| Application number: 2025/91370 | |
| What is the application for?: | REVISED AND ADDITIONAL INFORMATION RECEIVED: Demolition of existing dwelling and |
| Address of the site or building: | Land at, Gynn Lane, Honley, Holmfirth, HD9 6LF |

Client	YORKSHIRE COUNTRY PROPERTIES			
Project	GYNN LANE, HONLEY			
Detail	ROAD 1 CULVERT/HEADWALL CONSTRUCTION DETAILS (DRAWING 20F2)			
Dwn PW	Chkd	Date Mar 24	Scale 1:50 1:250	Dwg No. E24/8017/200_02

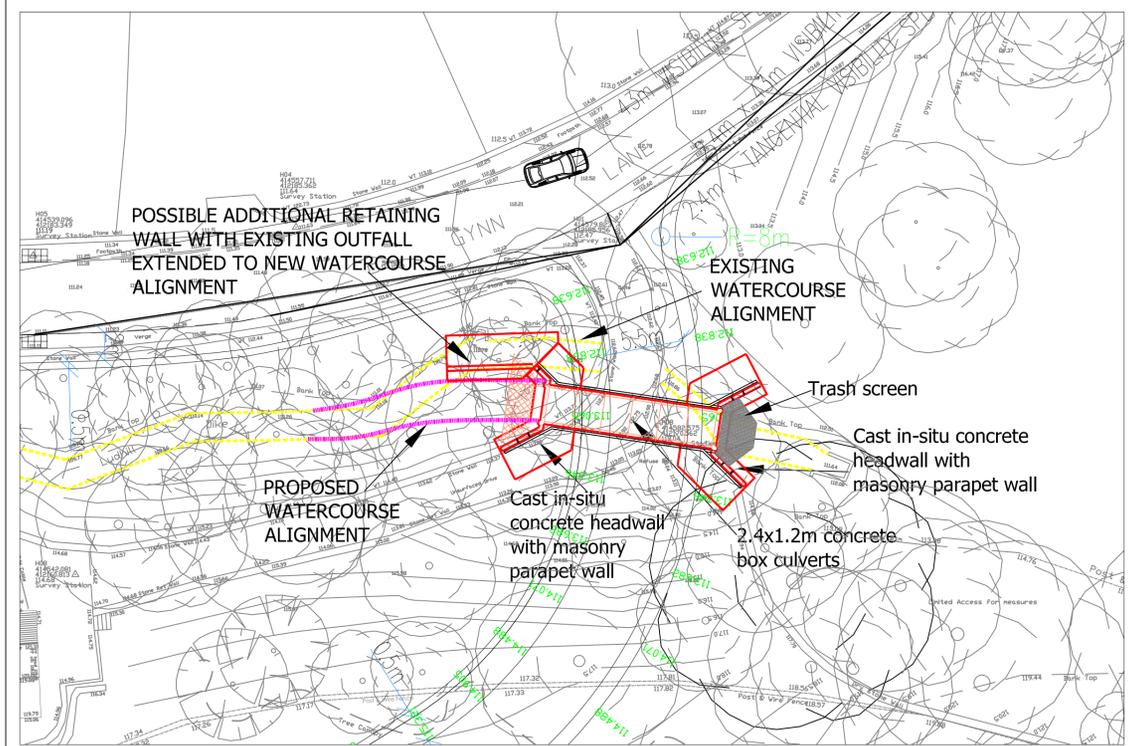
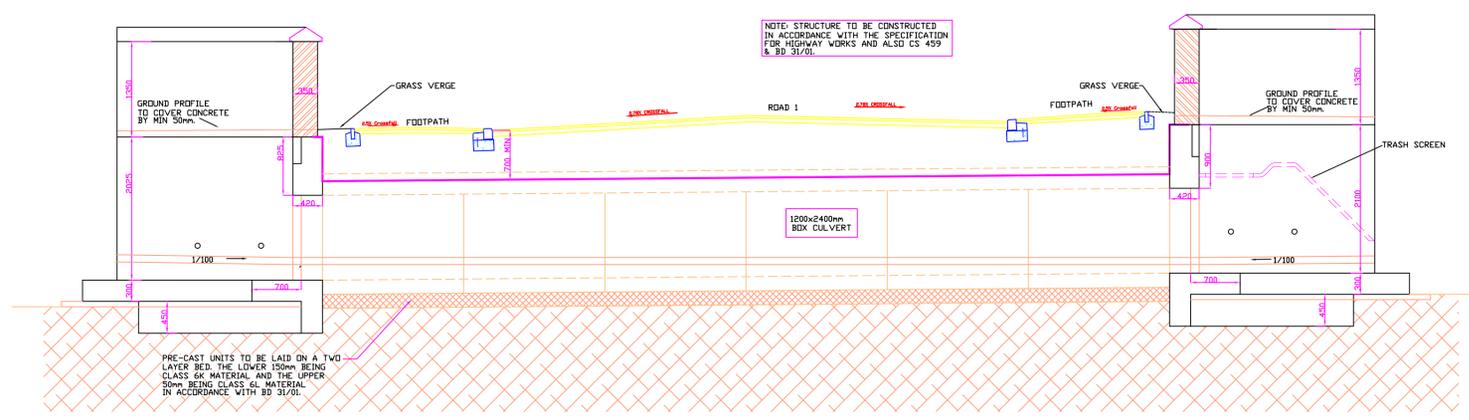
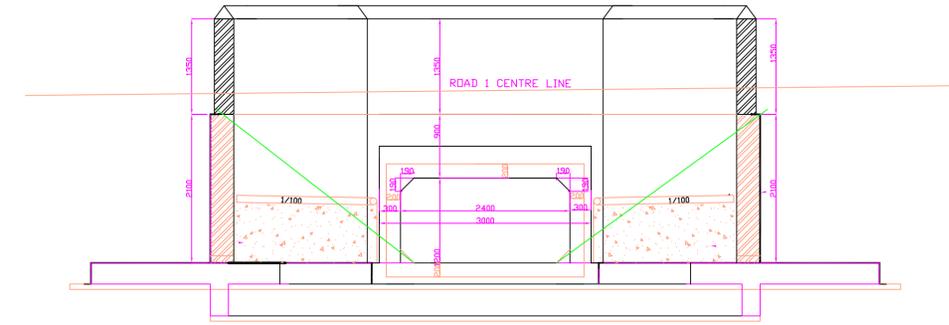
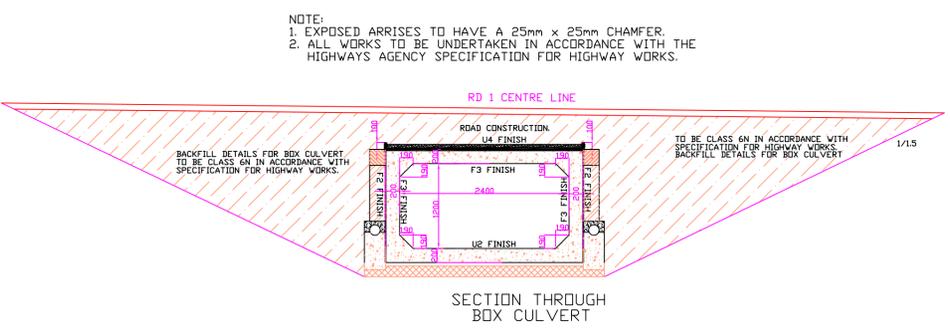
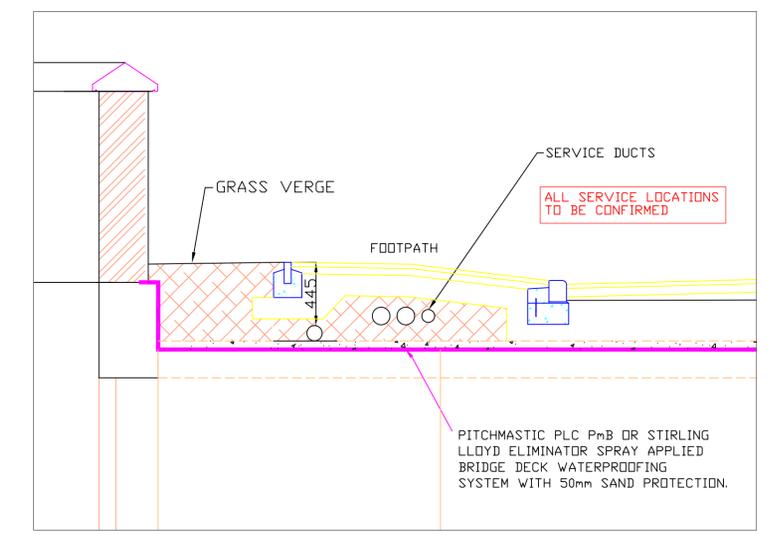
| <p>I have previously objected to, and signed a petition against this application. The revised and additional information does nothing to answer any of questions concerning this application. A new idea is to re-align Ludhill Dyke at the access to the site, but the stream at this point has land rising on either side so has no where else to sensibly go! The blockage of access to many houses on Gynn Lane/ Hall Ing Lane during the considerable earthworks required for proposed site entrance and the traffic problems of the heavy lorries getting to and from the site access in narrow Gynn Lane are not dealt with. This application in its current form is a total non starter, it is a sick joke.</p> | |
